Consultation Response from: KC Environmental Health (Pollution & Noise Control)

2024/92515 Victoria Tower Lumb Lane, Castle Hill, Almondbury, Huddersfield, HD4 6TA

Discharge of details reserved by conditions 3 (Construction (Environmental Management Plan), 8 (access road works), 18 (kitchen waste water), 20 (archaeological investigation), 29 (biodiversity) and 30 (public right of way) of previous permission 2018/93591 for erection of restaurant/café/bar, six guest rooms, exhibition/interpretation room, WCs, terrace, car parking and ancillary accommodation

KGB Series Grease Trap Interceptor

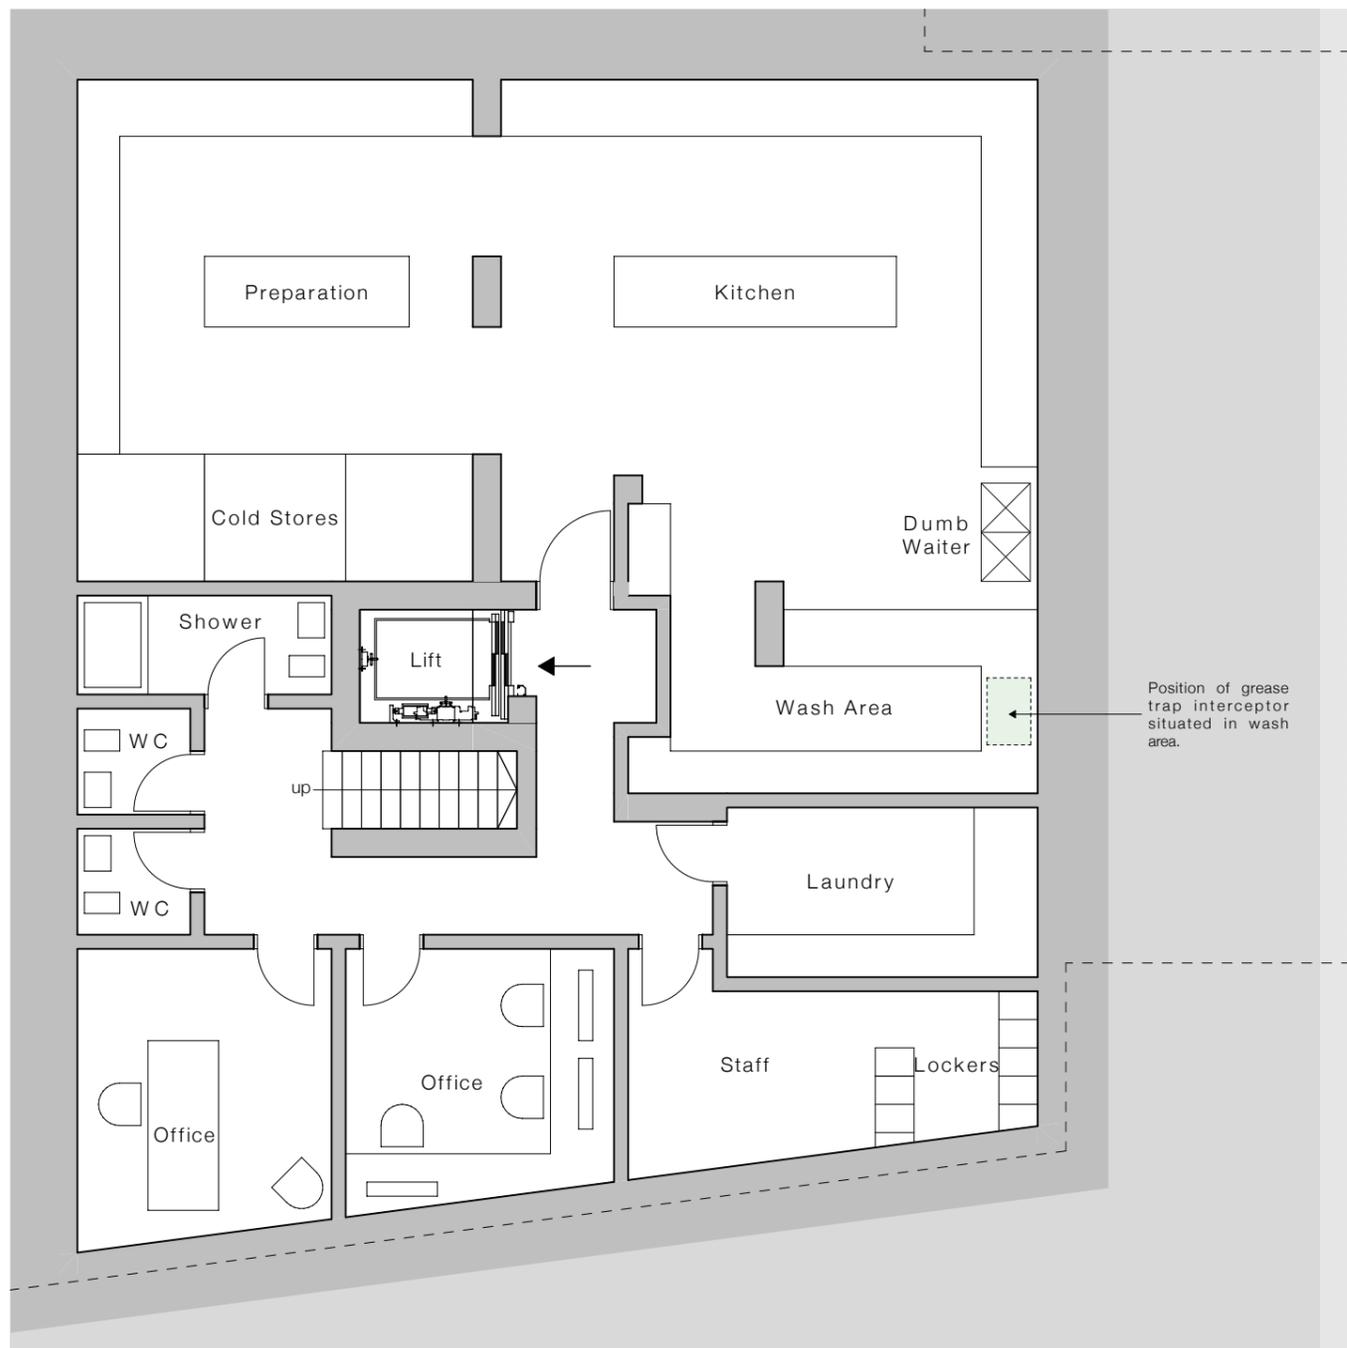
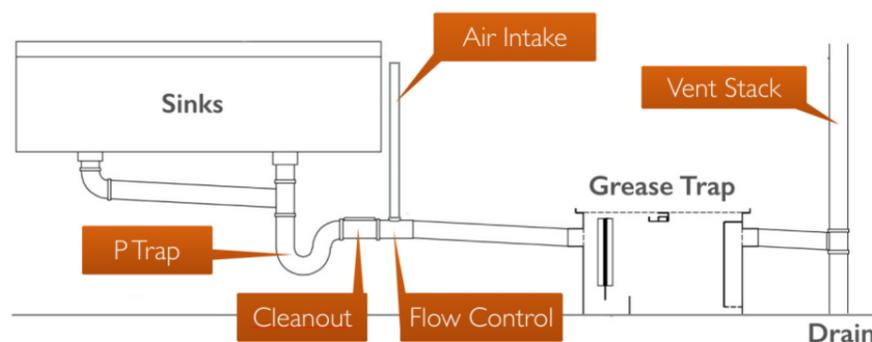
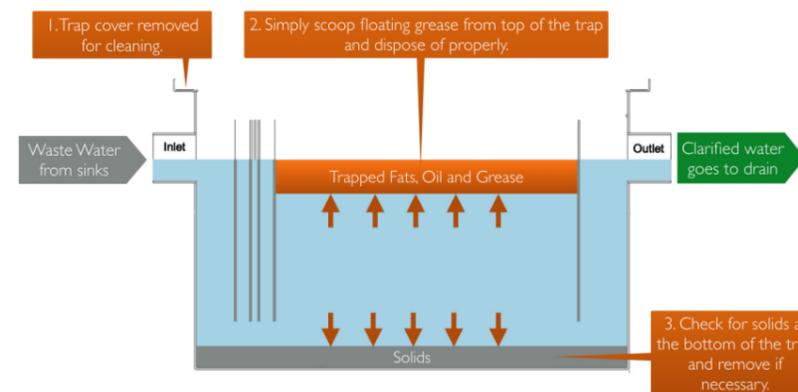
The plan by One17 titled Drawing 3287(SK)110, shows the location of the KGB Series Grease Trap Interceptor to be installed.

This is acceptable to Environmental Health; the condition requires the approved system shall be implemented prior to first operation of the development and shall be retained throughout the lifetime of the development.

We accept the details of the interceptor to be installed. The condition requires installation prior to first operation of the development and retention throughout the lifetime of the development.
